Our Case Number: ABP-316119-23

Re: DART+ South West Electrified Heavy Railway Order - Hazelhatch & Celbridge Station to Heuston Station, and Hesuton Station to Glasnevin
County Dublin and County Kildare

Development: DART + South West Electrified Heavy Railway Order – Hazelhatch & Celbridge Station to Heuston Station to Glasnevin.
Co. Dublin & Co. Kildare.

DART+ South West Electrified Railway Order 2023

WORKS LAYOUT PLAN
HAZELHATCH STATION AND SURROUNDS
SCALE 1:1250 (@A0)

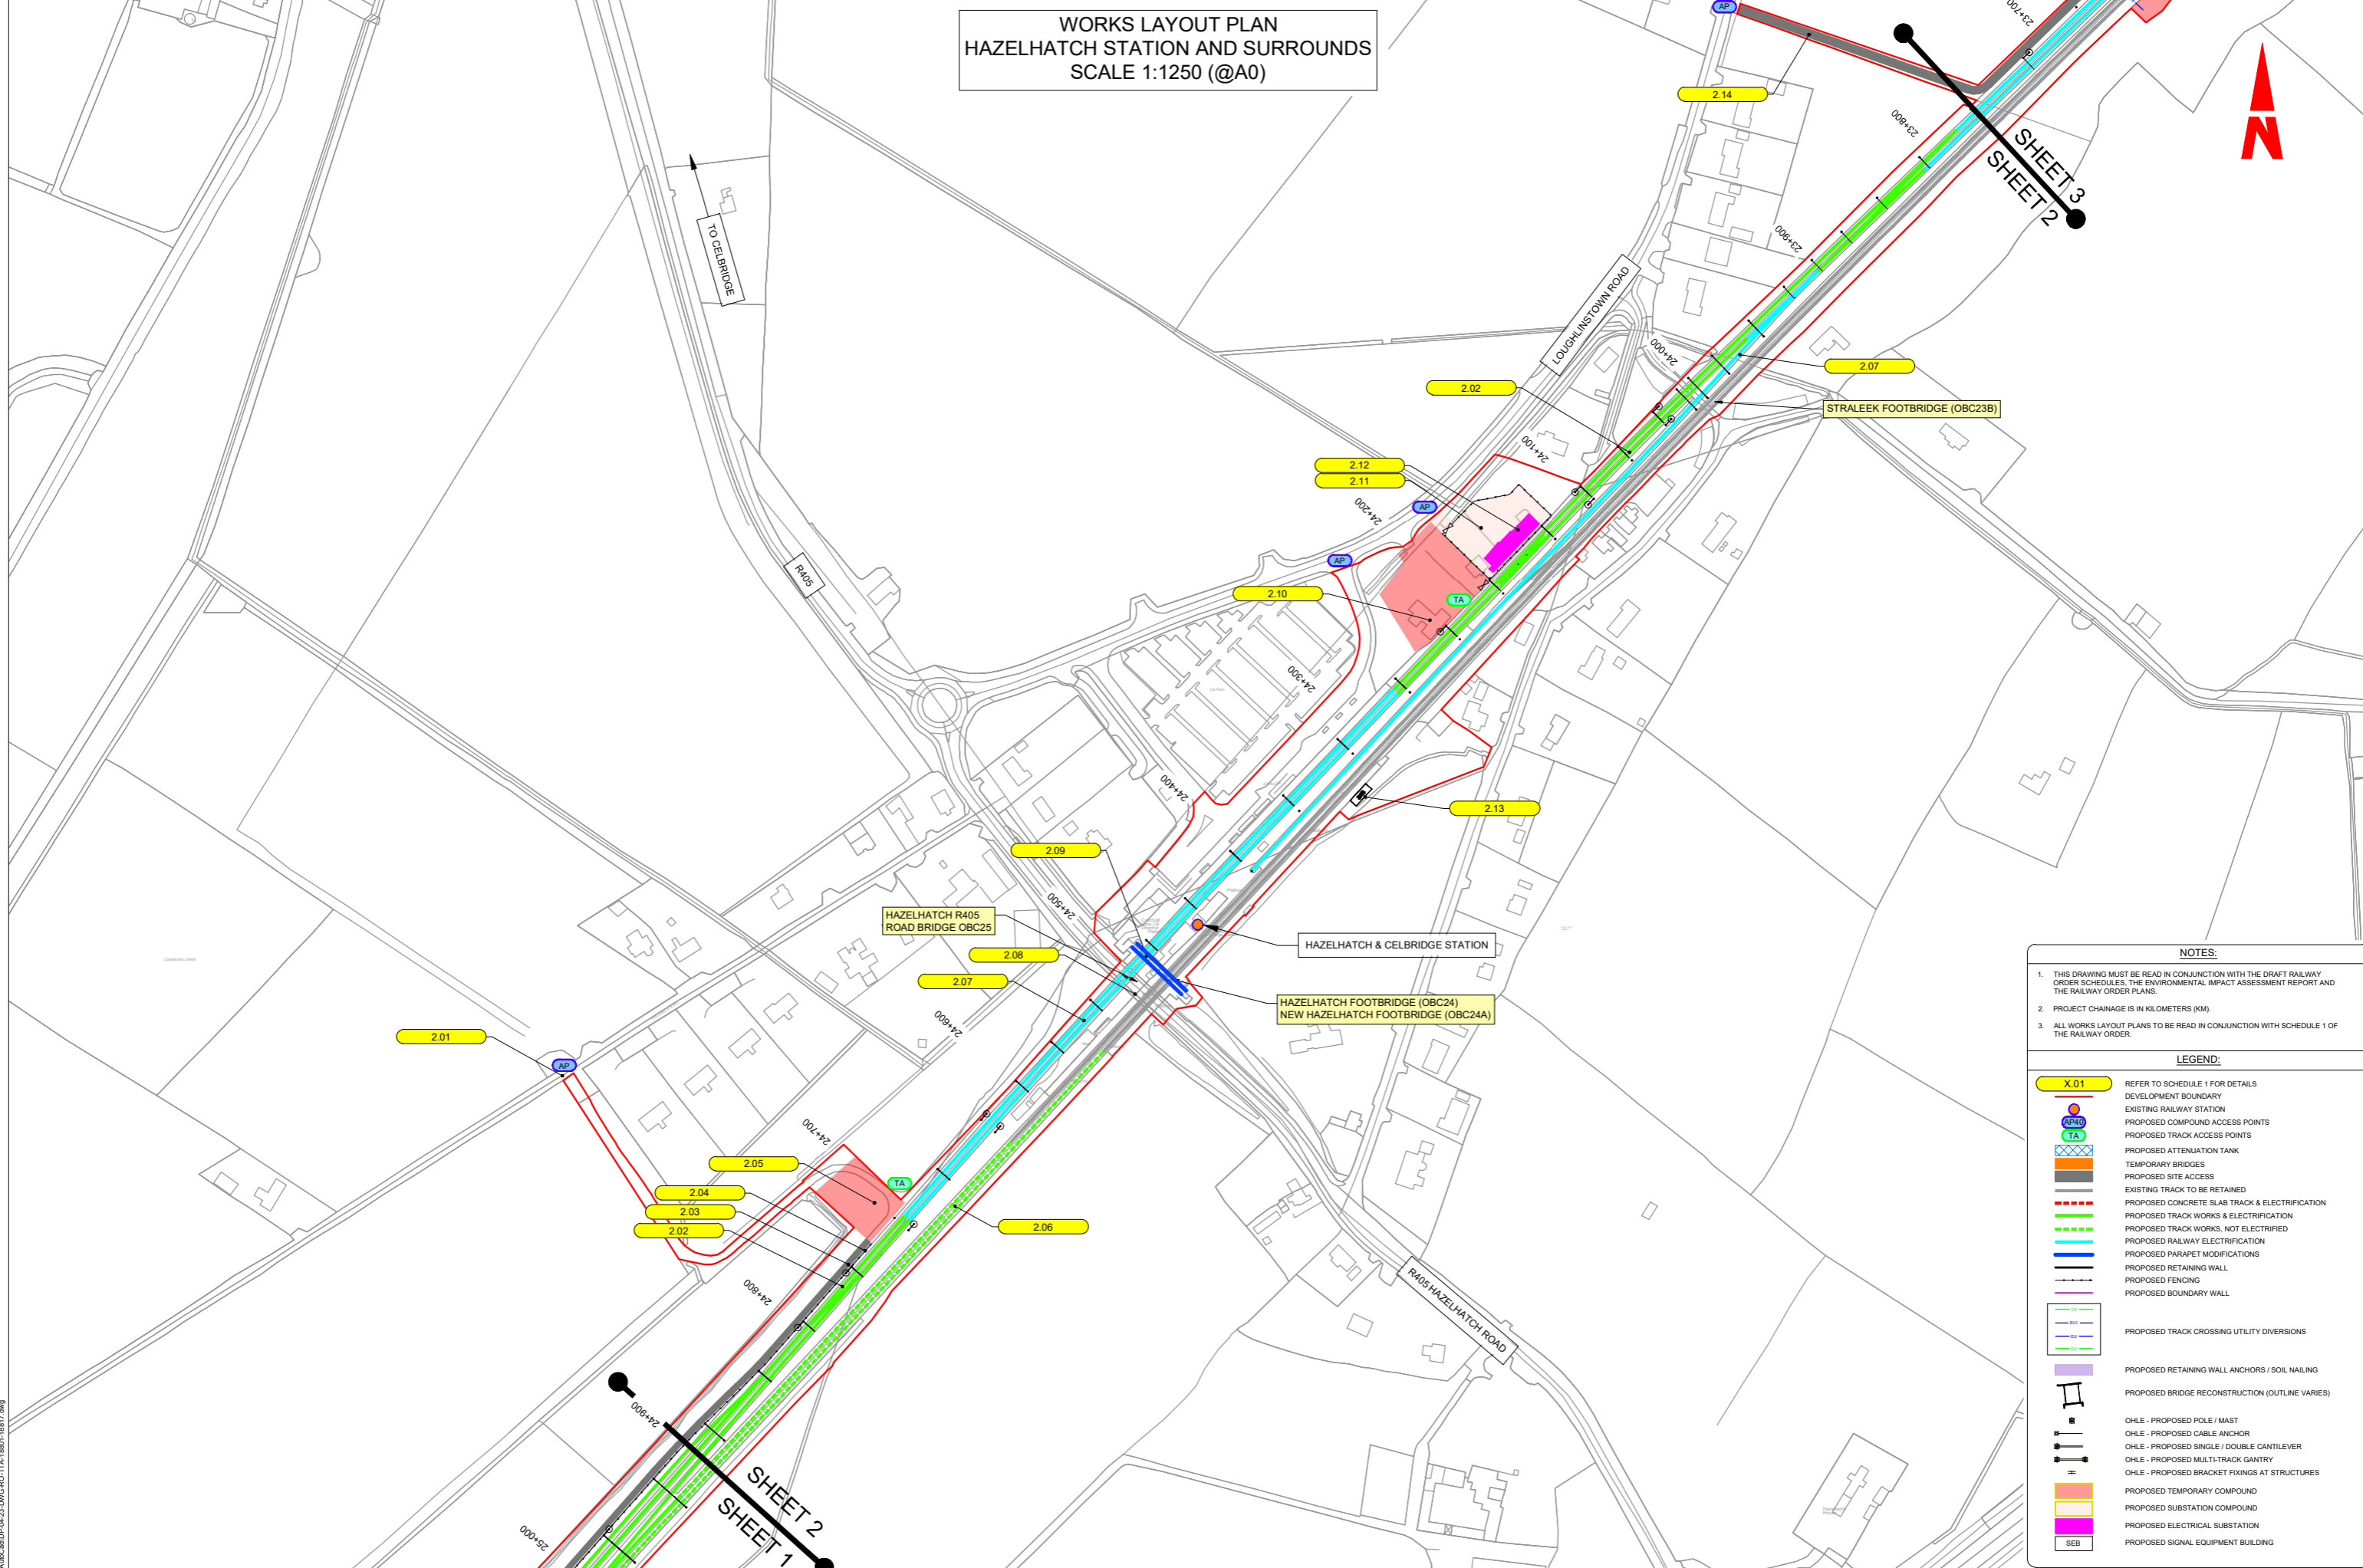
There will be a substantial increase in customers using the improved service that will put additional pressure on the access and parking facilities at the Hazelhatch & Celbridge Station. This increase will need to be quantified in an assessment, and it is the position of Kildare County Council that additional parking should be provided as part of the Project or delivered concurrently with the commencement of operations. It is recommended that the upgrading of the facilities at the Hazelhatch & Celbridge Station should be included in the Project which should include improved access for all road users, additional parking bays, electric charging points and cycle parking.

Concerns have been raised that should additional parking not be provided and improved access arrangements and active travel measures not be put in place that this will give rise to haphazard parking in the vicinity of the station potentially creating a traffic hazard.

There will be a substantial increase in customers using the improved service that will put additional pressure on the access and parking facilities at the Hazelhatch & Celbridge Station. This increase will need to be quantified in an assessment, and from our analysis additional car parking demand should be provided for as part of the Project and delivered concurrently with the commencement of operations. It is

recommended that the upgrading of the facilities at the Hazlehatch & Celbridge Station should be included in the Project which should include improved access for all road users, additional parking bays, electric charging points and cycle parking.

Concerns have been raised that if this is not the case then there will be inadequate parking facilities in the Hazlehatch & Celbridge Station and some customers may have no option but to park outside the Station and on the nearby public roads which will create a traffic hazard.

WORKS LAYOUT PLAN
STACUMNY LANE AND SURROUNDS
SCALE 1:1250 (@A0)

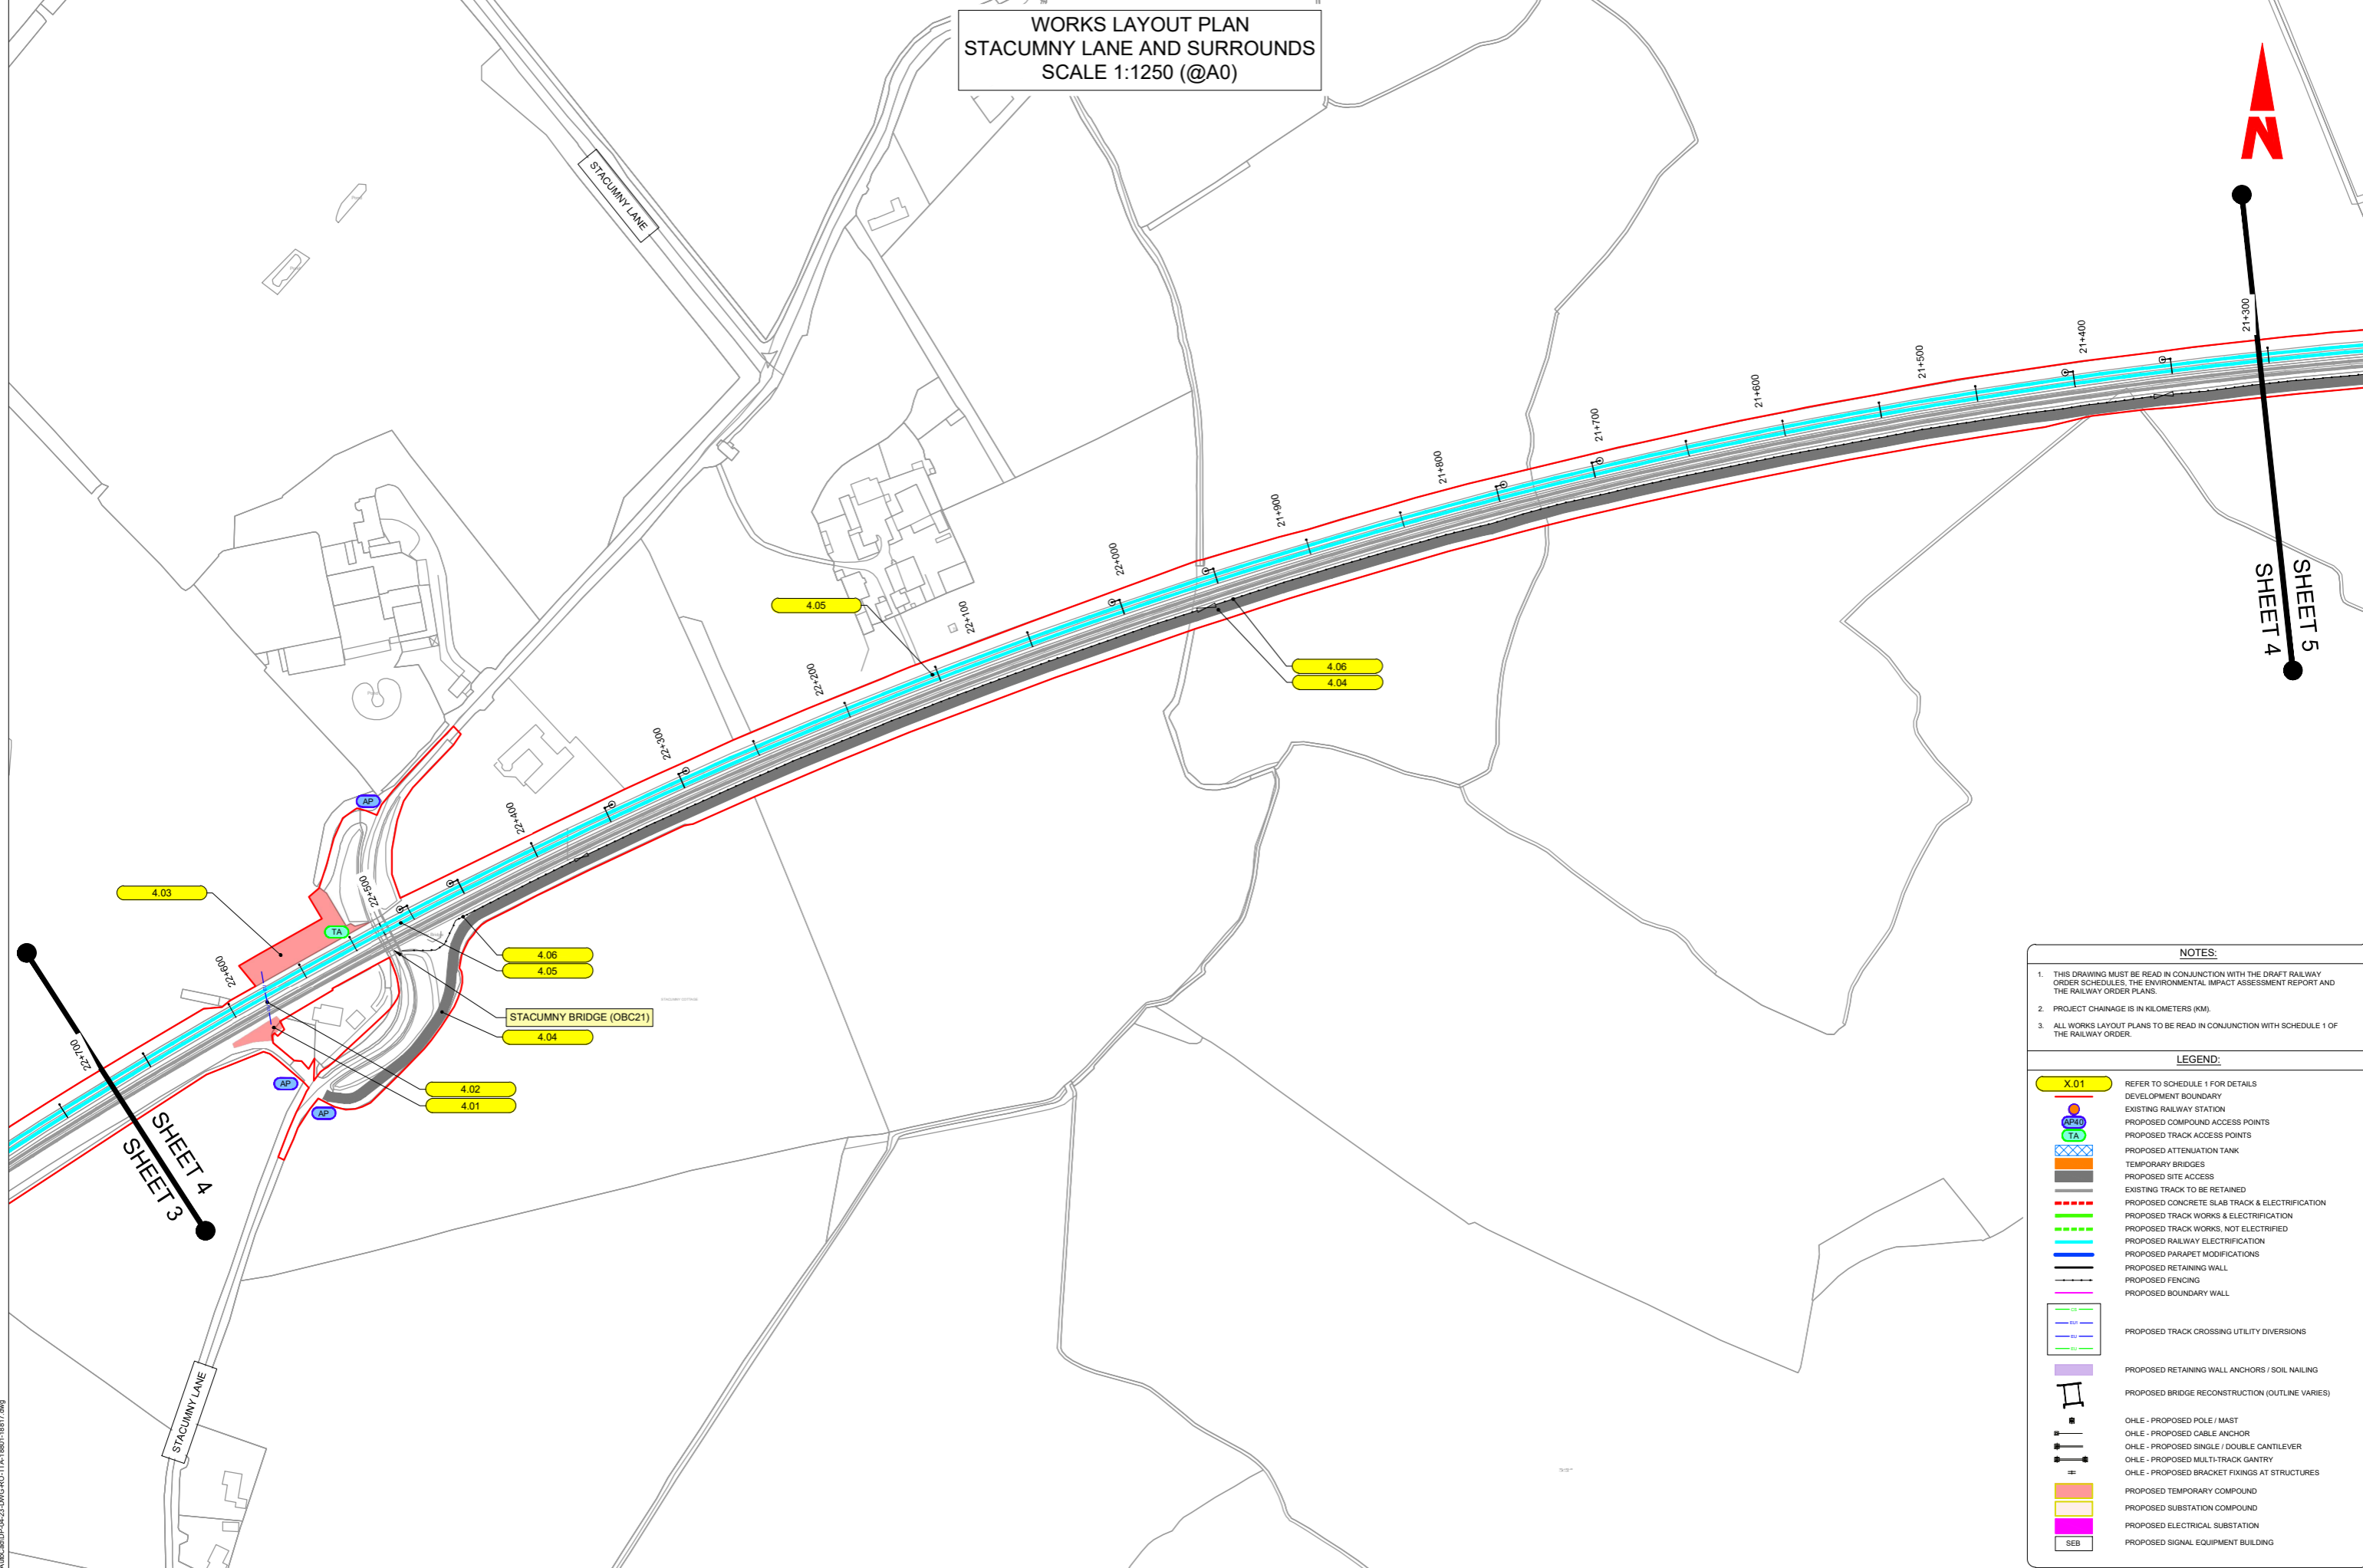
A 19th century lime kiln in Stacumny is located adjacent the existing railway lines. The lime kiln is included in Kildare County Development Plan 2023-2029, RPS Ref. B11-12. Additional tree planting / screening should be included adjacent the Stacumny lime Kiln to lessen the visual impact of the proposed supports for the overhead line equipment on the protected structure.
